From: Stuart Corbey
Sent: 18 March 2019 18:47
To: Lynnyrd Wolfe
Cc: Planning.Responses
Subject: FW: EP/180/18/PL - The Boathouse, 131A Sea Road & Coastal Caravan Park
Attachments: Block Plan Rev.1.pdf; Site Location Plan Rev.1.pdf; Ground Floor Plan.pdf; Indicative Site Plan.pdf; Rear Elevation- North.pdf; Side Elevation - East.pdf; Side Elevation - West.pdf; First Floor Plan.pdf; Front Elevation - South.pdf

From: Peter Cleveland [REDACTED]
Sent: 07 March 2019 09:30
To: Stuart Corbey
Subject: RE: EP/180/18/PL - The Boathouse, 131A Sea Road & Coastal Caravan Park

EXISTING FRONT(S)
ELEVATION
SCALE : 1:50

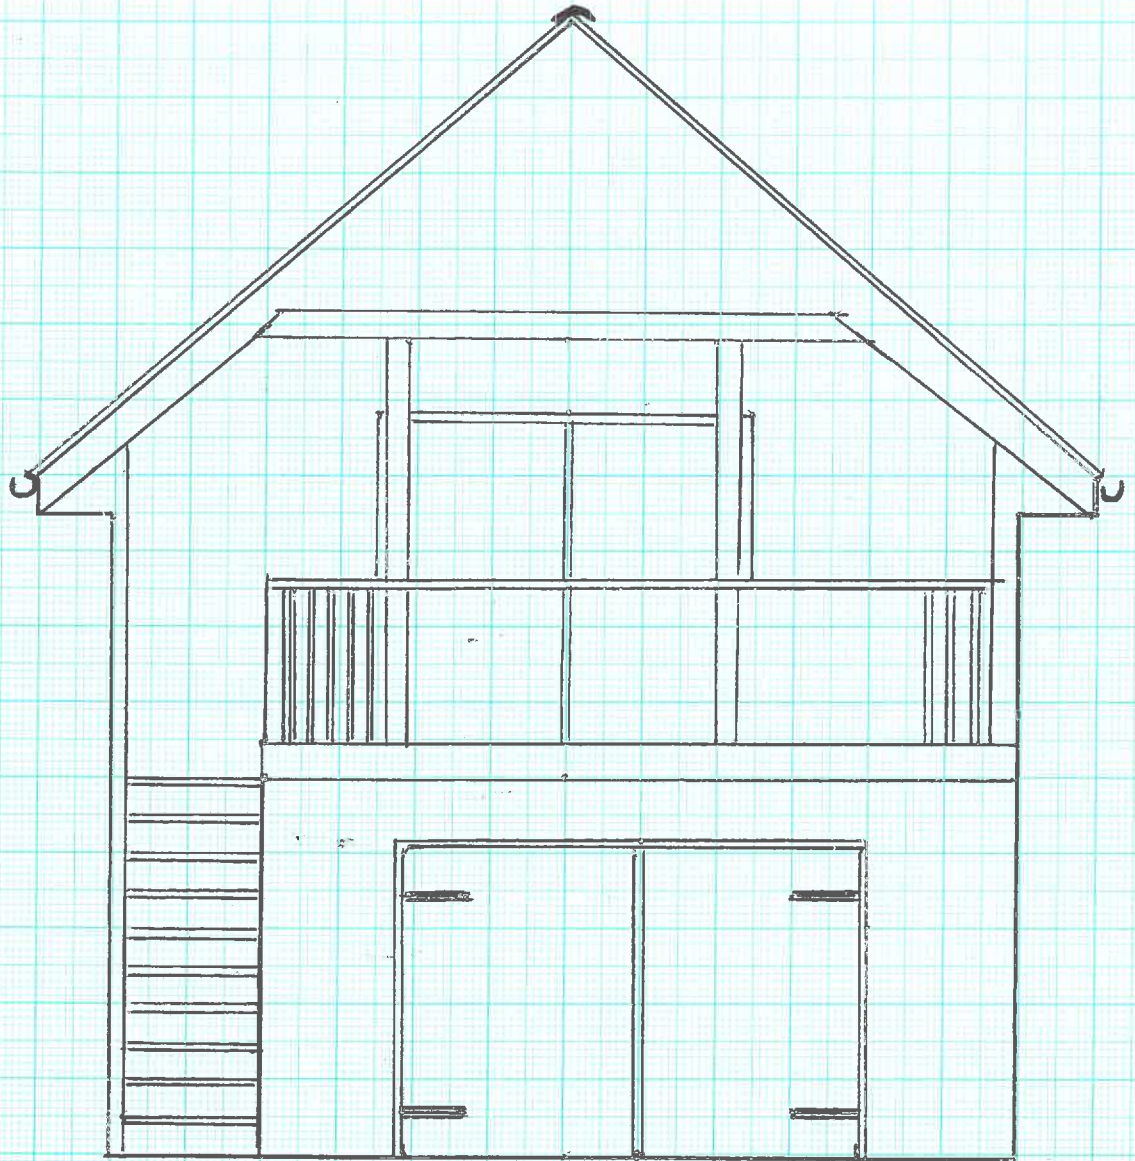
- a) We need the location and block and caravan site plan numbered... (it's helpful if not essential)
- b) The term 'existing and proposed' need to be removed from all other plans - e.g. floor plans et al
- c) The flue added to all elevation plans (as current not shown)
- d) Confirmation that the plan listed as existing front elevation is omitted (as the building has been fully developed, therefore the plan is not relevant)
- e) Can you confirm the relevance of the section plan – demonstrating the concrete foundation – as this in our view can also be omitted if only applies to Building Regulations and thus not a planning matter.

- a) Numbered Location and Block Plans
- b) Floor Plans and Elevations updated to remove 'existing and proposed' annotation
- c) Flue added to elevations
- d) This is a recent change, but happy to confirm removal of the existing front elevation as requested
- e) Section plan confirms construction detail, but is for information purposes only now as the site is modelled to fall outside of the flood zone.
